I have raised a number of queries regarding East Park Energy [REDACTED] and feel that some major points that I have not seen covered, or explained in any detail in the discussions attended to date.

In my objections under the above reference I have raised many issues opposing this development, some picked up by many others also, but have a few specific items that I would appreciate specific answers to, these are :

Status
DCO Application

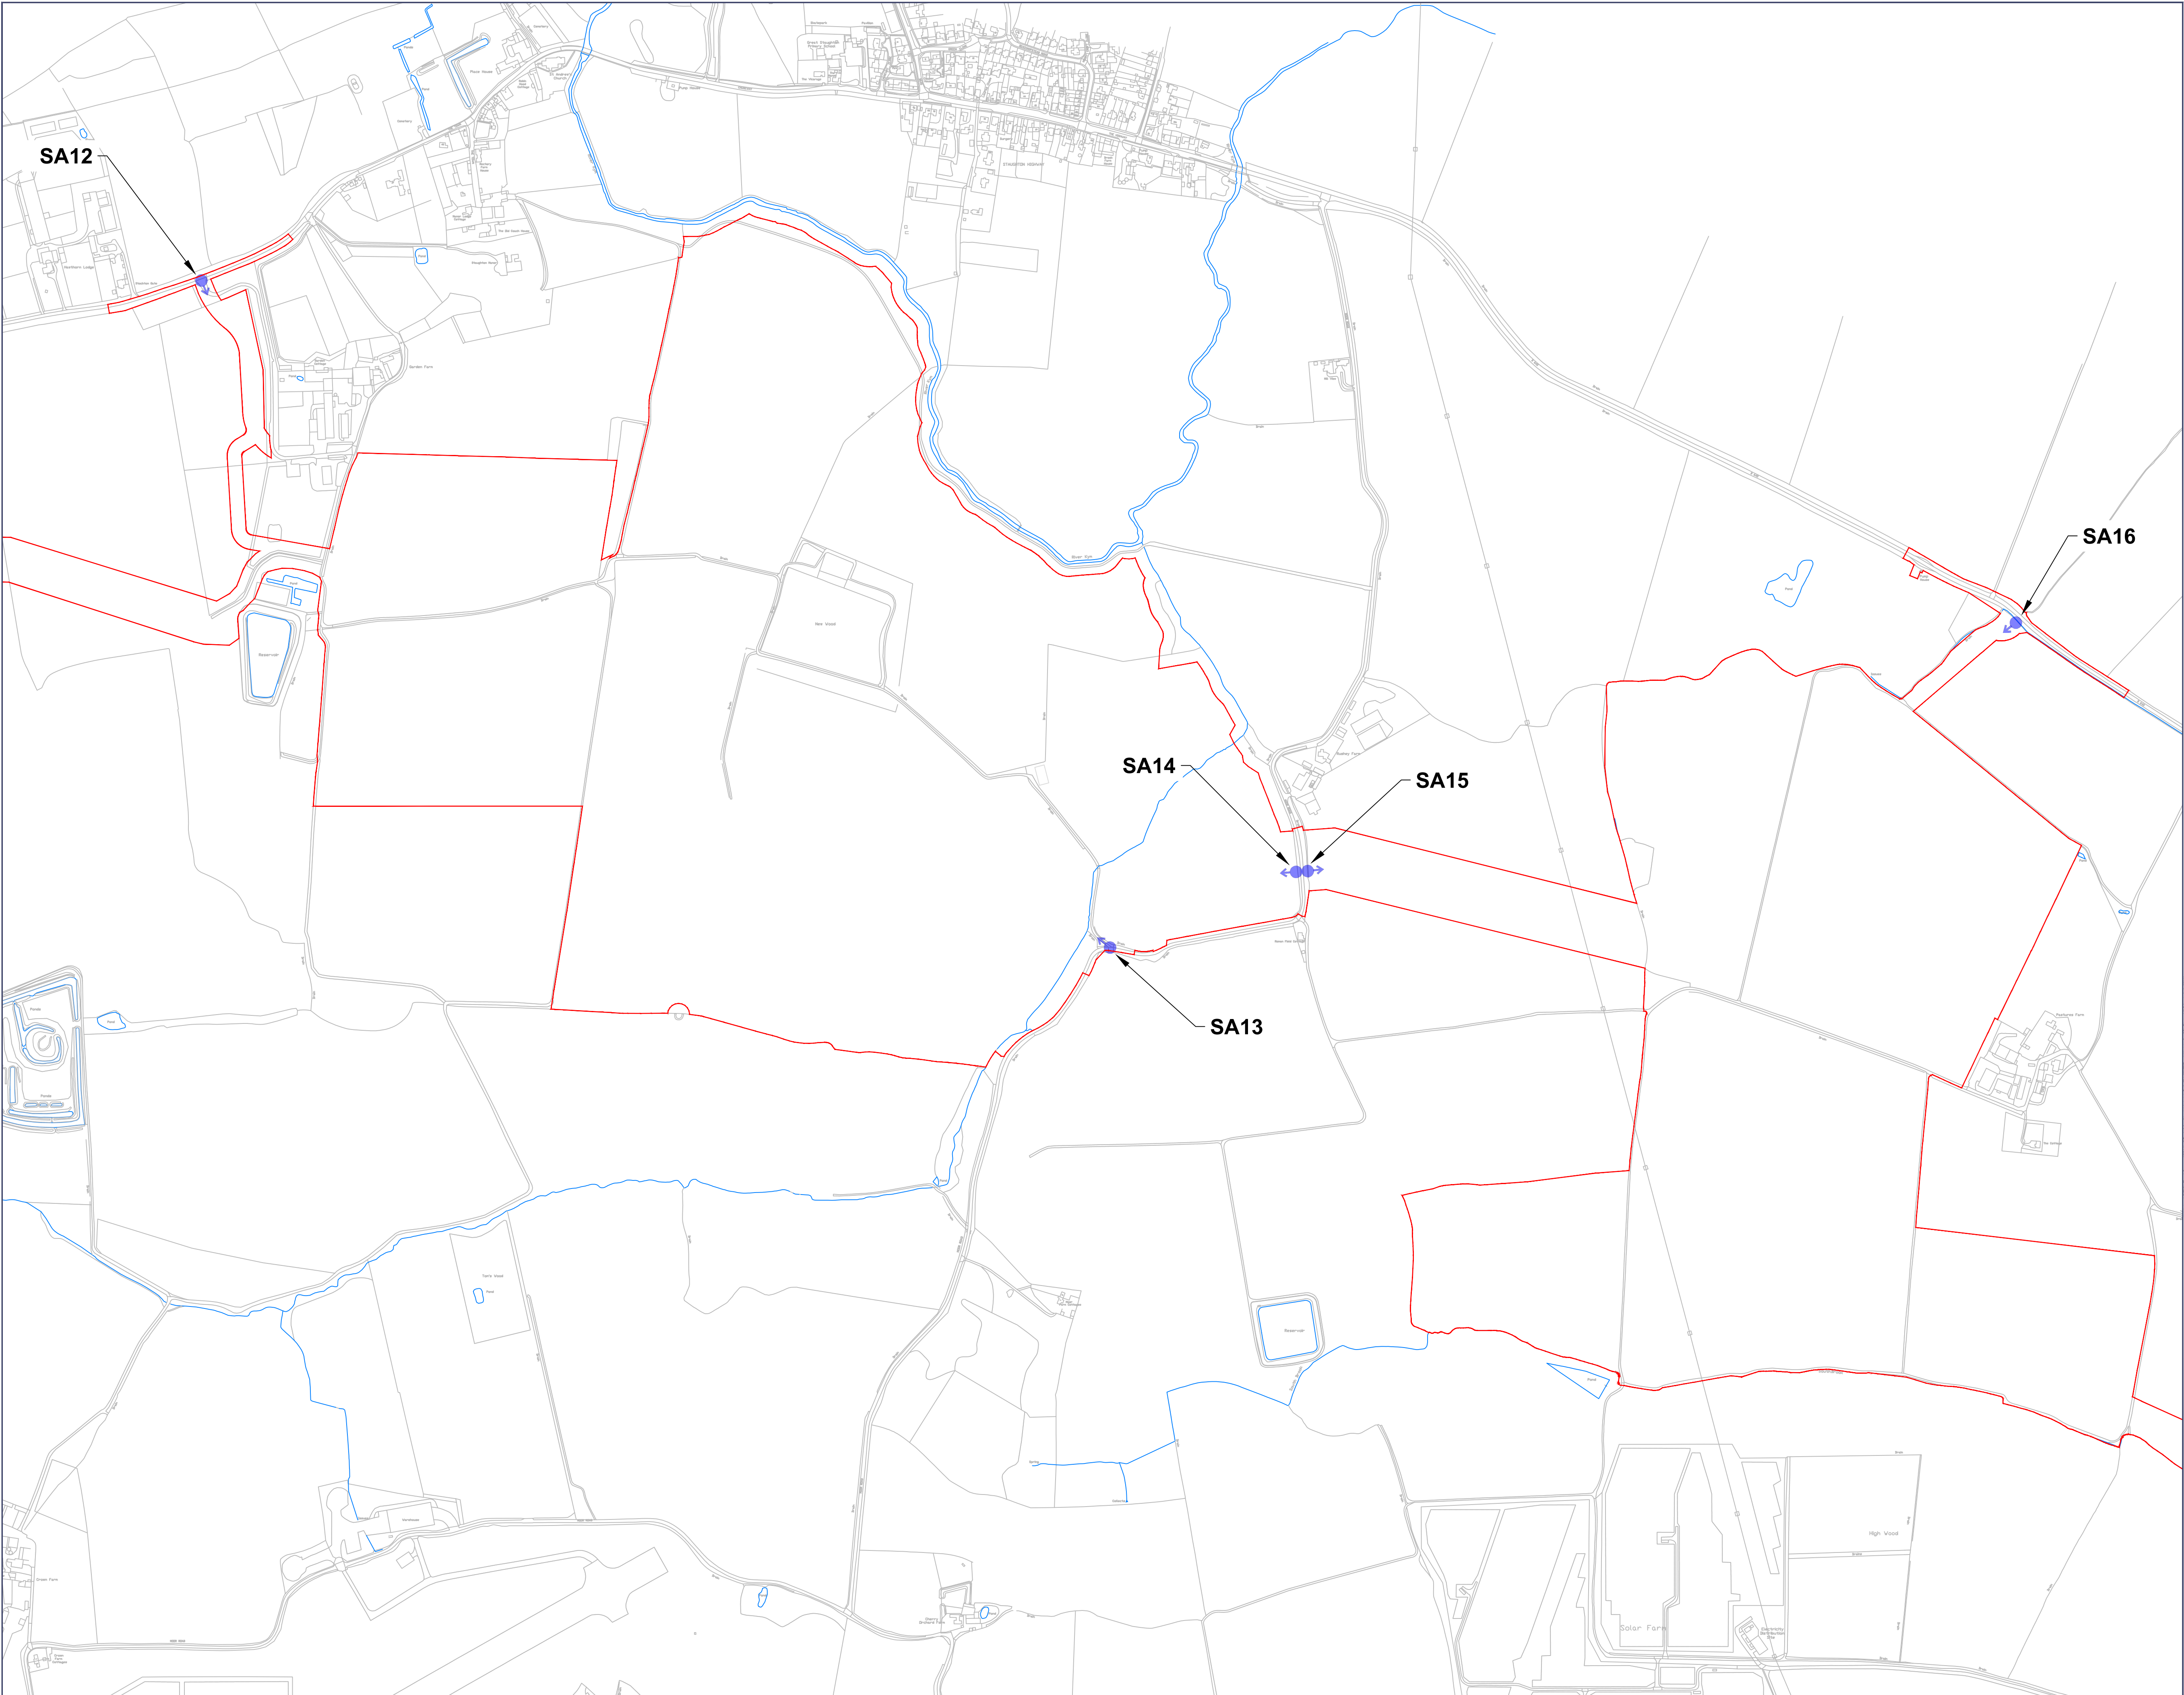
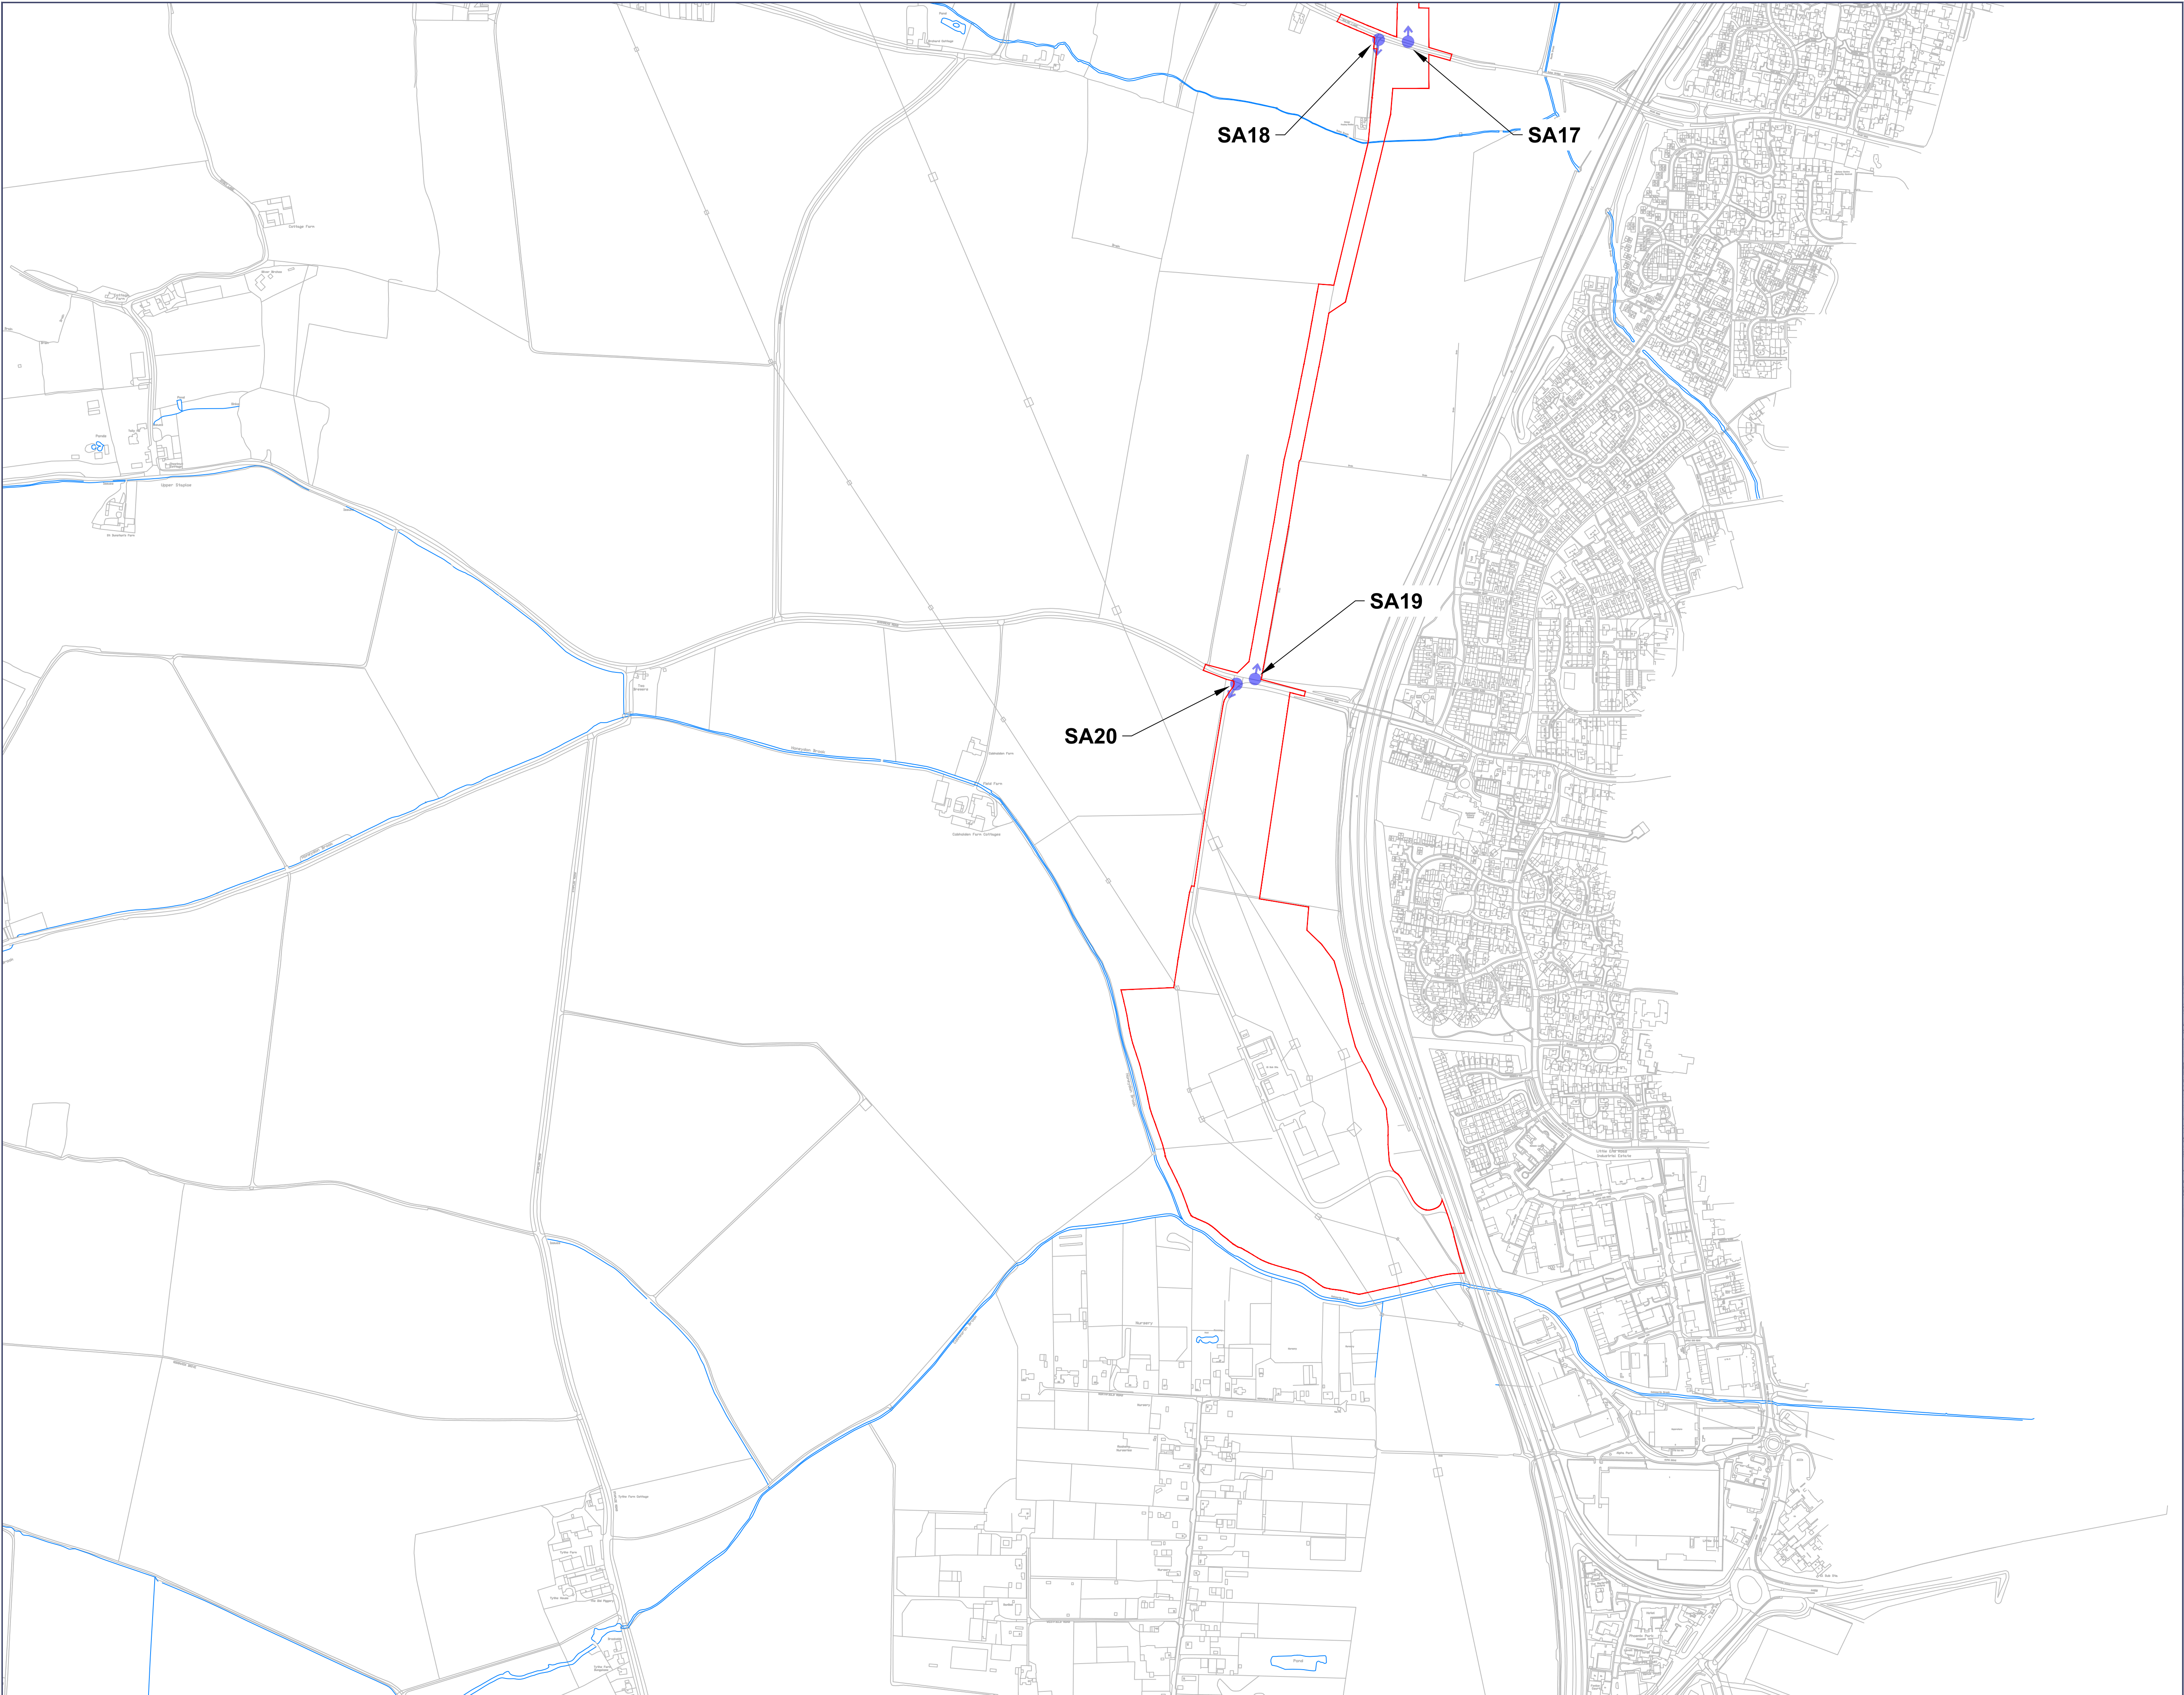
Access site point at Green end in Little Staughton (see pics in my objection), how can this be a sensible place on a bend right next to houses in Little Staughton be the right place, dangerous as on a bend and widening the road to accommodate will impact the village character and residents with volume of traffic crossing the road or queued up . Surely must be better places for it to be cited in many straighter bits of road and away from residents ?

What damage will be done when putting all the access points in to get this construction completed, how big will the access points be and what level of hedge. Tree screening will be damaged for all site access points, also what limitation on signs that are likely to be there for 3 years will be put in place ?
